A/67/20/L

*Listed building for the erection of 3 No. outbuildings within the rear garden cabins for the purposes of 1) a garden office 2) Workshop/Storage Area 3) Garden Room with Kitchenette & Shower/Toilet Room.*

## BLOCK PLAN 1/500

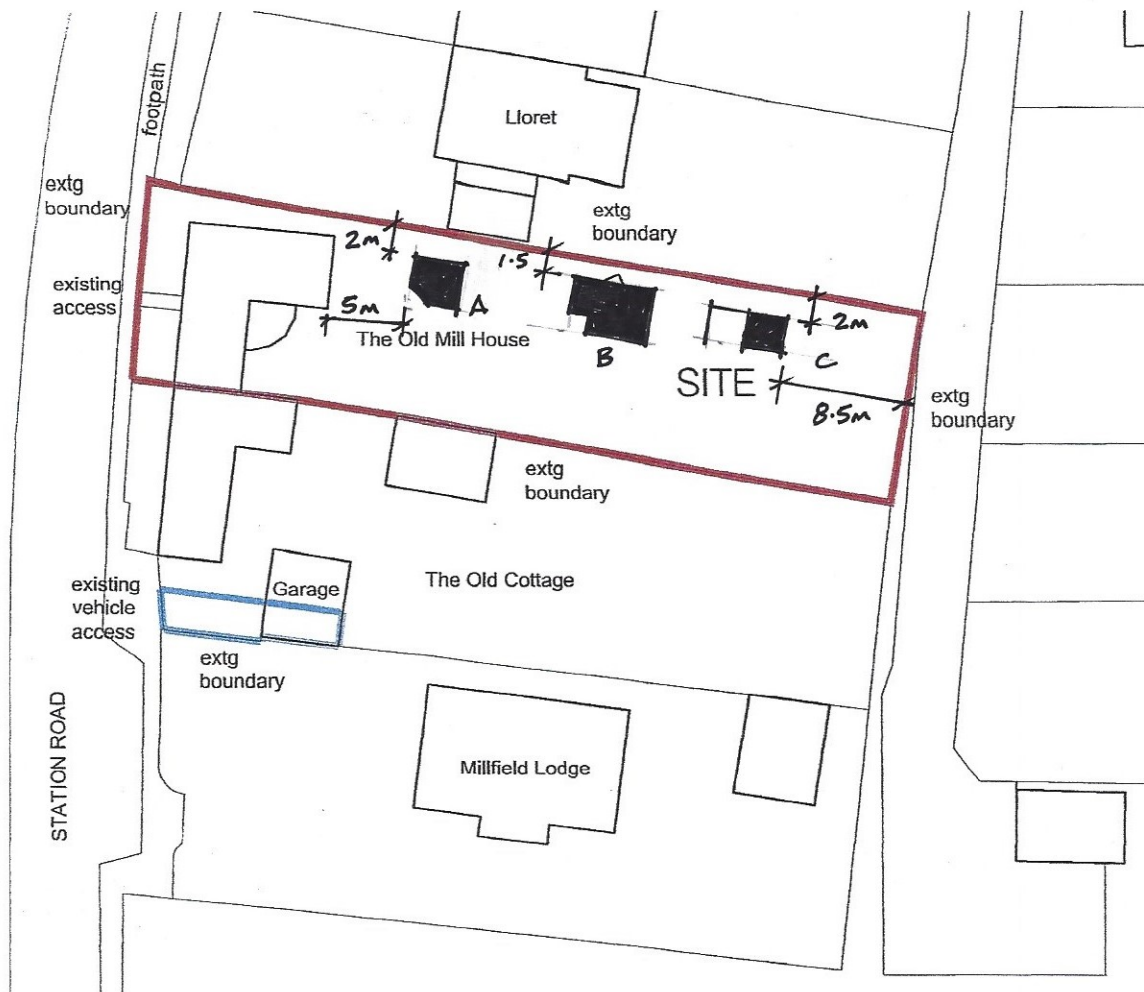
The heritage statement identifies that the new structures will replace recently removed ones, which it is stated were in a poor state of repair and dangerous. It is not clear why three structures are required in the curtilage of the house, nor why the previous locations were chosen. Further, it is not fully clear how the structures will be treated externally i.e. painted/stained/left a natural colour?

It is considered that the structures themselves are fairly simple in terms of their appearance which will not detract from the listed building, and if treated sensitively, will not cause harm. Such structures are also not permanent and can be fairly easily removed at any time. They can be treated in a number of different ways which will reduce their impact, and it is suggested that the use of landscaping could be the most effective method. This is especially important for the shed closest to the listed building.

If minded to approve the application, you may wish to condition details of how the structures will be treated.
